From: [REDACTED] **On Behalf Of** CCD Planning Consultations
Sent: 21 September 2017 15:46
To: Planning.Responses
Cc: Derek Whittington
Subject: RE: Planning Consultation on: EG/69/17/PL

SUBJECT: EG/69/17/PL - 4 No. live/work units, Research & Development propagation building & growing area, garden room, fuel store & greenhouse to main dwelling & formation of new access.
This application is a Departure from the Development Plan.

Swallowfield, Eastergate Lane, Eastergate, West Sussex, PO20 3SJ

Fire Tender	7.334m
Overall Length	2.280m
Overall Width	3.495m
Overall Body Height	0.380m
Min Body Ground Clearance	2.280m
Track Width	5.00s
Lock-to-lock time	6.000m
Curb to Curb Turning Radius

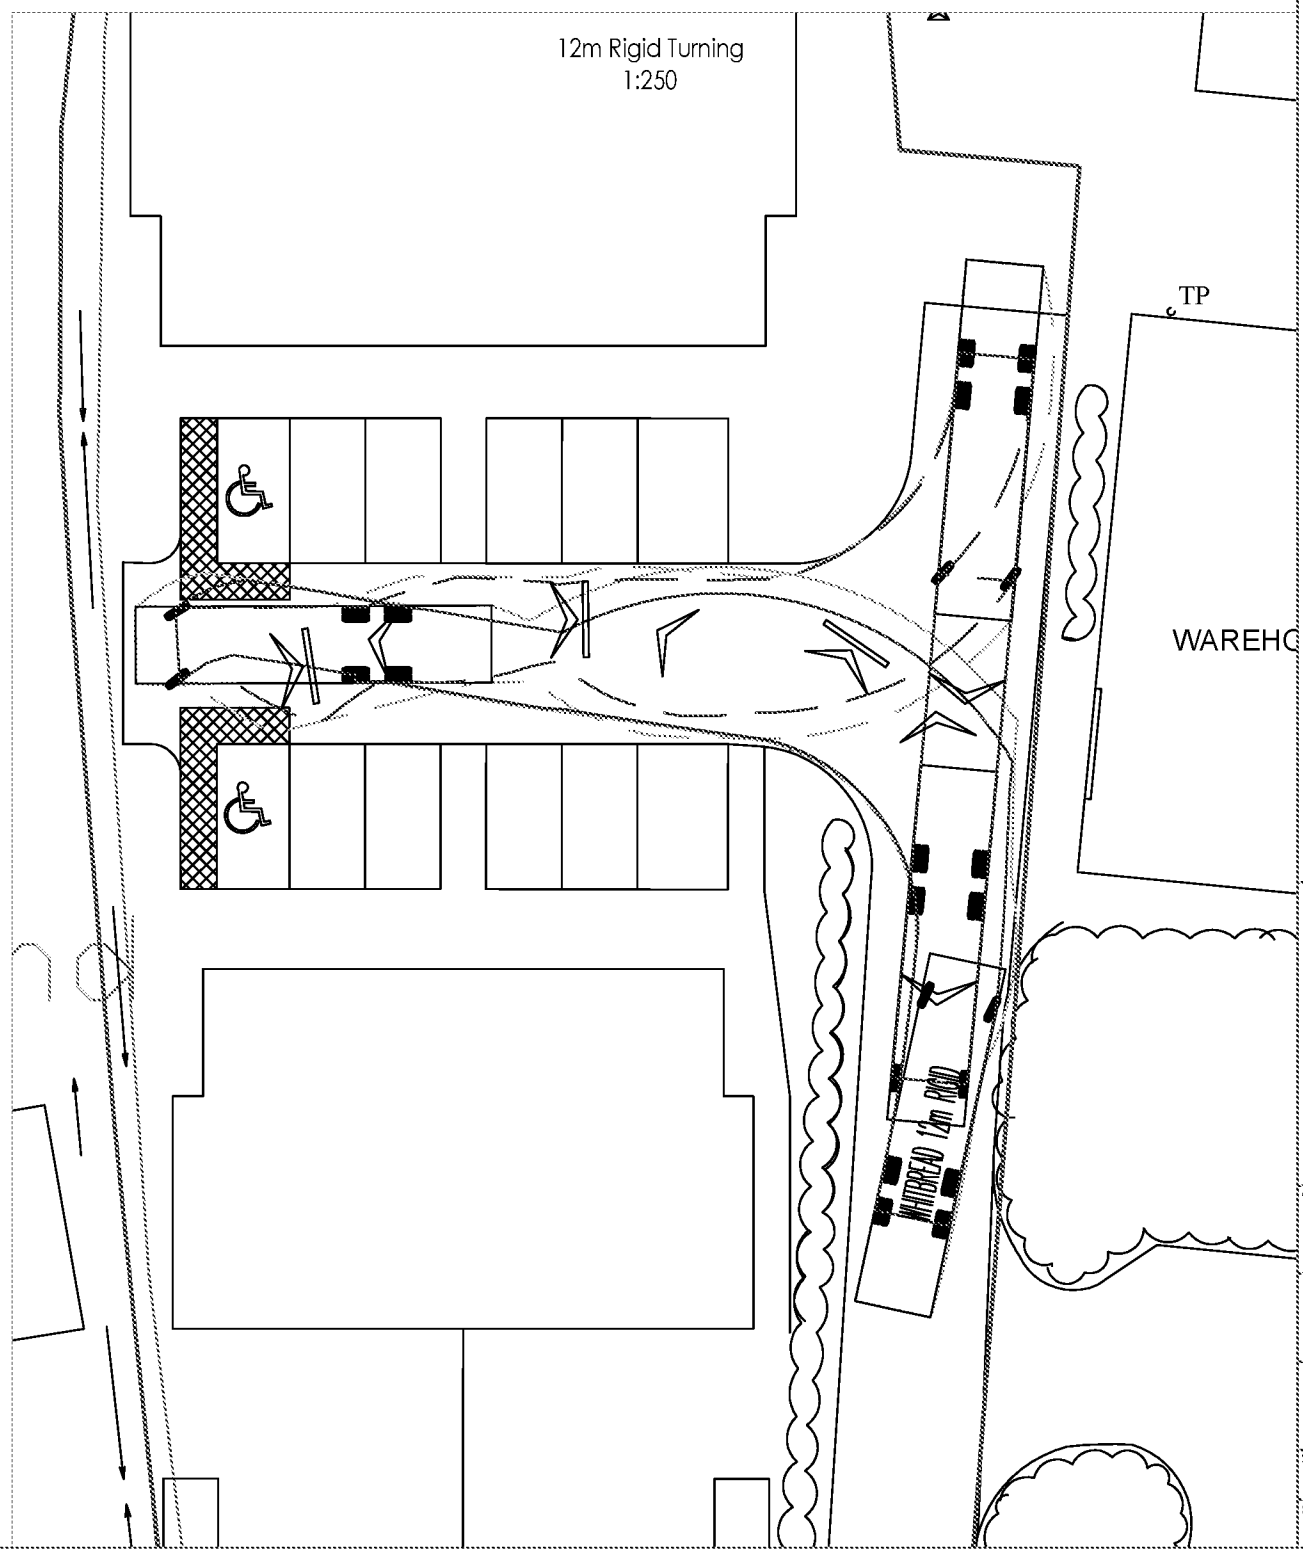
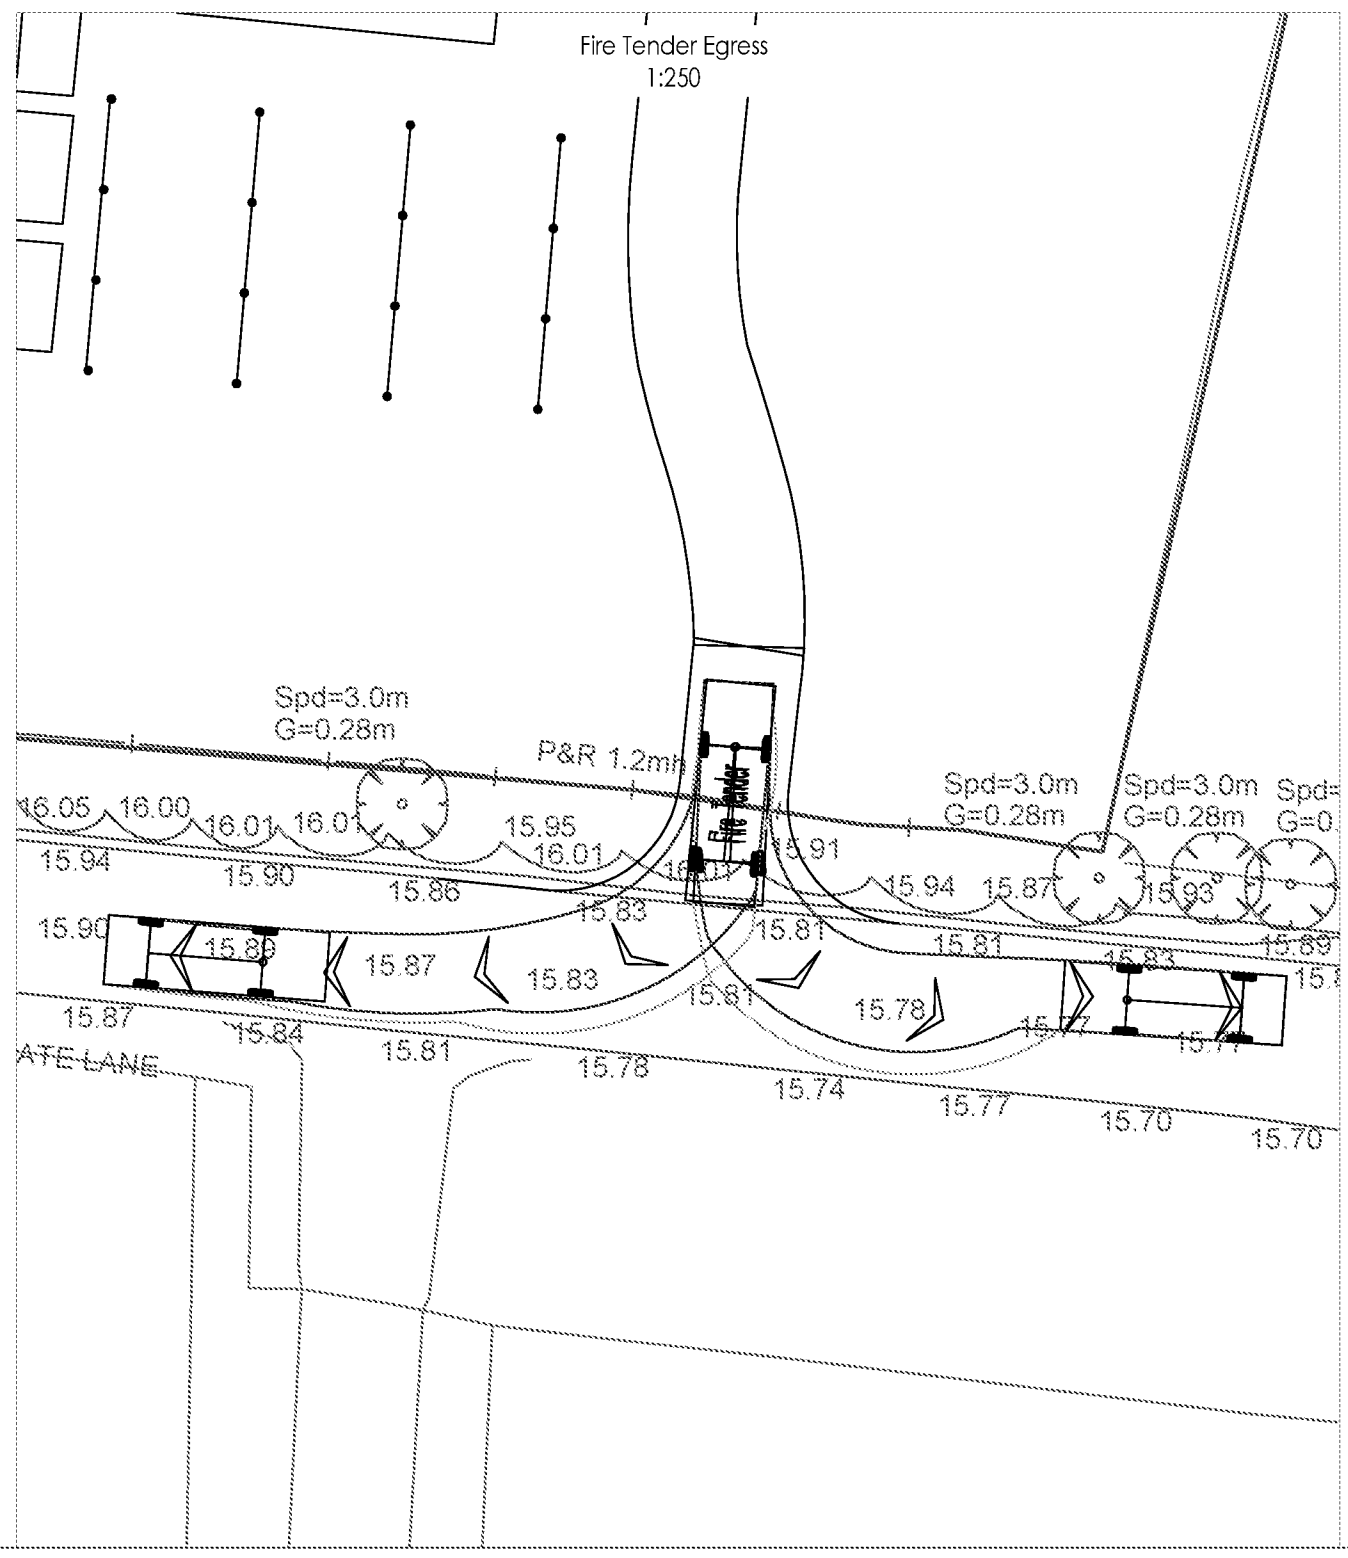
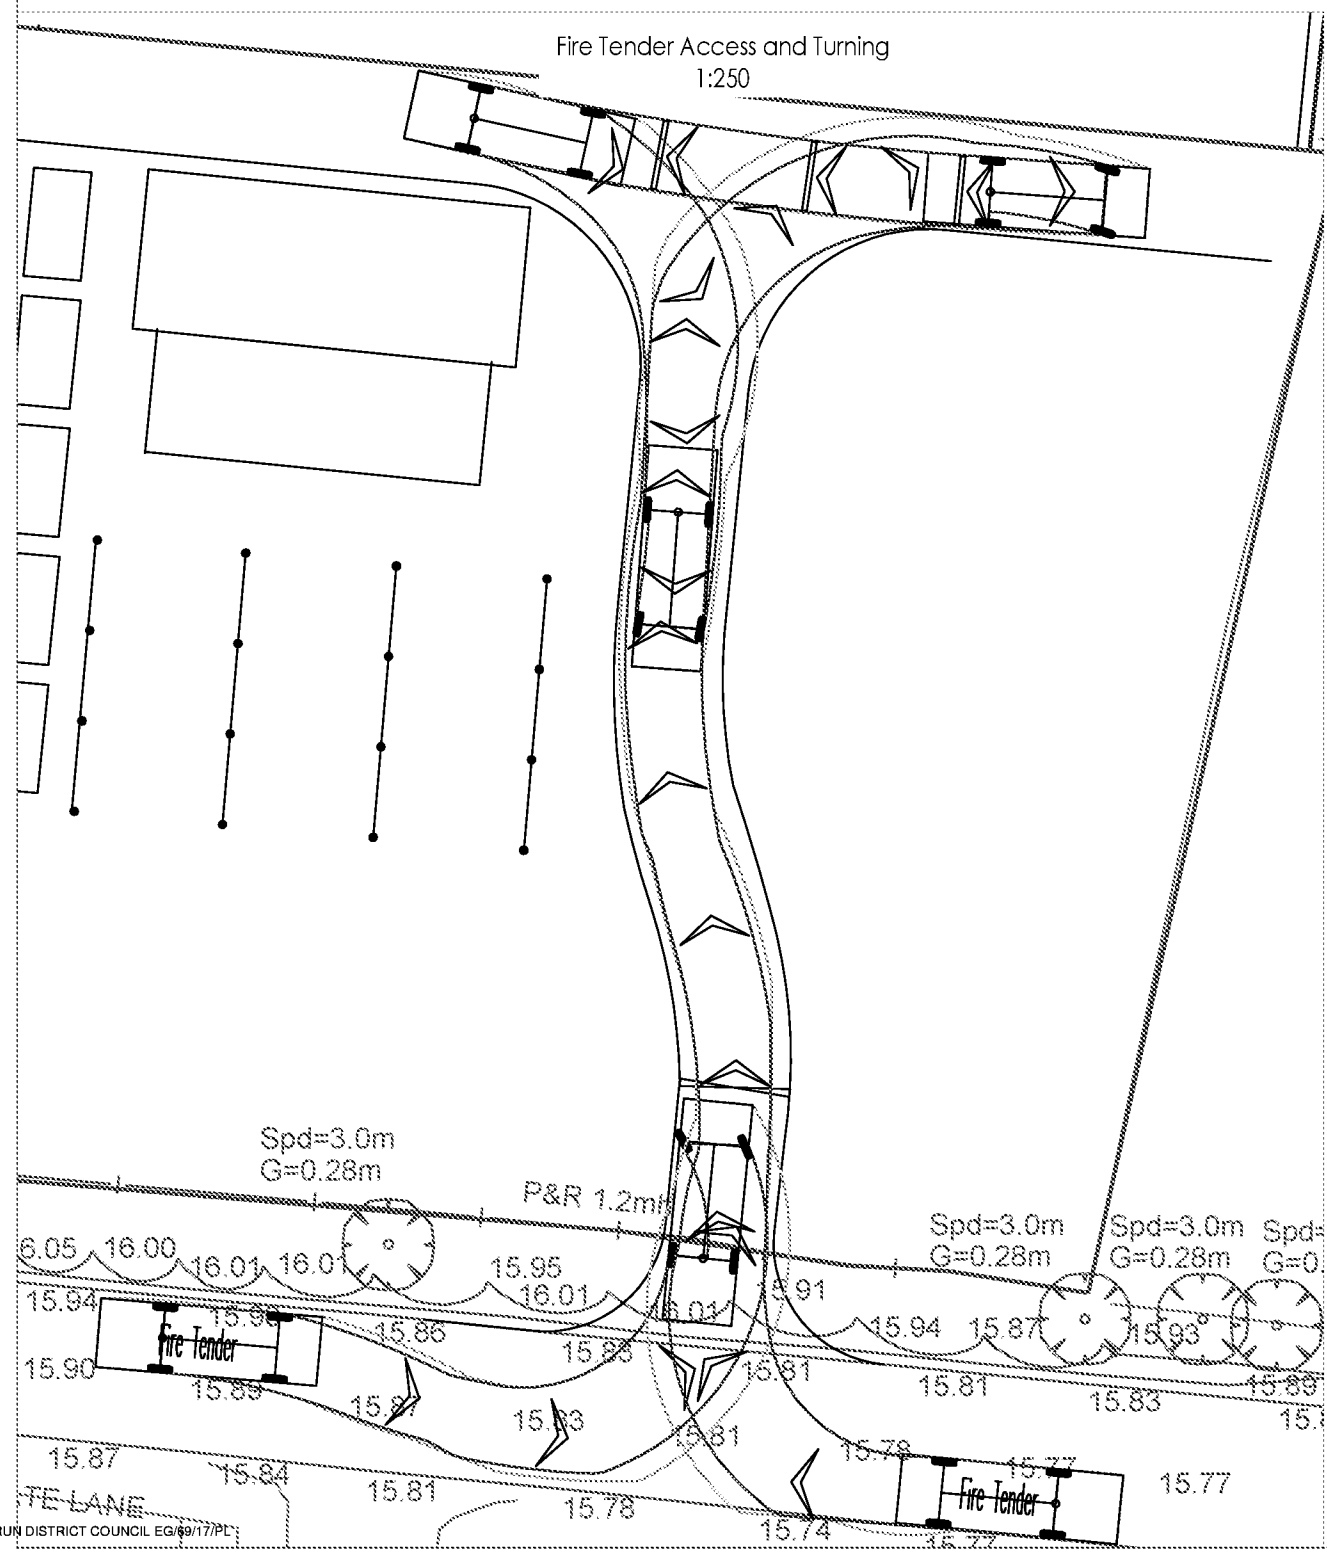
It is proposed that the existing vehicle access to the live/work units will be formalised with priority junction road markings. The existing geometry of this access will facilitate the anticipated vehicle movements and be suitable for emergency vehicles. This is demonstrated in dwg. 2016/3448/001 via swept path analysis. The applicant should provide a more detailed plan indicating the proposed road markings and a Road Safety Audit (RSA) should consider both accesses with emphasis on markings for existing access.

A new 3.7m wide bellmouth access is proposed to serve the eastern section of the site with 4m wide corner radii. It has not been demonstrated that two vehicles would be able to pass at the access or within the site. The proposed gate will be set back 7.1m however it is not clear whether this is suitable. The applicant should provide tracking diagrams and clarify whether any larger vehicles will utilise the site, which may require a set back of the gate by 10m to allow such vehicles to wait clear of the highway. The TS states that swept path tracking has also been demonstrated for the new access showing a large van accessing the site, however this is not apparent on dwg. 2016/3448/001. We note the internal access is annotated to be used by 'light' vehicles only however consideration to refuse collection vehicles and Fire Appliance should be given.

Design Manual for Roads & Bridges (DMRB) would be applied as the relevant standards considering vehicle speeds are above 40 mph. The desirable minimum for posted limit of 40 mph is 120m Stopping Sight Distance (SSD). Paragraph 3.2.5 of the TS states that 'desirable minimum' calculation set out in DMRB has been used. Paragraph 1.26 of Highway Directive TD9/93 (DMRB) states that relaxations below the desirable minimum are not permitted on the immediate approach to junctions. Nevertheless WSCC Departure from Standard (DfS1/4) allows that Manual for Streets 2 (MfS2) methodology be used for calculating SSD at accesses which meet certain criteria. In this instance the DfS would be acceptable and the LHA concur that a reduced splay of 103m to the west and 107m to the east is suitable to the recorded speeds. 106.8m has been demonstrated to the east though the LHA is satisfied that using a slight offset into the carriageway edge the full 107m would be achievable. This has been demonstrated within publically maintainable land for both the existing and proposed access. Nevertheless extensive cutting back of the hedgerow may be required to facilitate these splays. The LHA will be undertaking a site visit to confirm that the demonstrated splays are achievable and the applicant should note this advice also relies on the speed counters being taken in a suitable location.

The swept path plans do not demonstrate turning within the site for larger vehicles such as a Fire Tender and delivery vehicles. Considering the warehouse is to remain on site it is anticipated that space for turning of larger delivery vehicles is required. More detailed swept path plans should be provided for the proposed access also.

The TS states that bin collection is to be from Eastergate Lane as existing. Nevertheless, bin storage areas are shown within the plot of each dwelling and it is not clear whether these will be wheeled to the highway, which is in excess of 25m distant. If Refuse Collection vehicles are to serve the site internally then a turn at the culmination of the access drive should be demonstrated via swept path analysis.

Turning within the eastern section of the site should also be suitability demonstrated for a Fire Appliance and waste collection arrangements clarified.
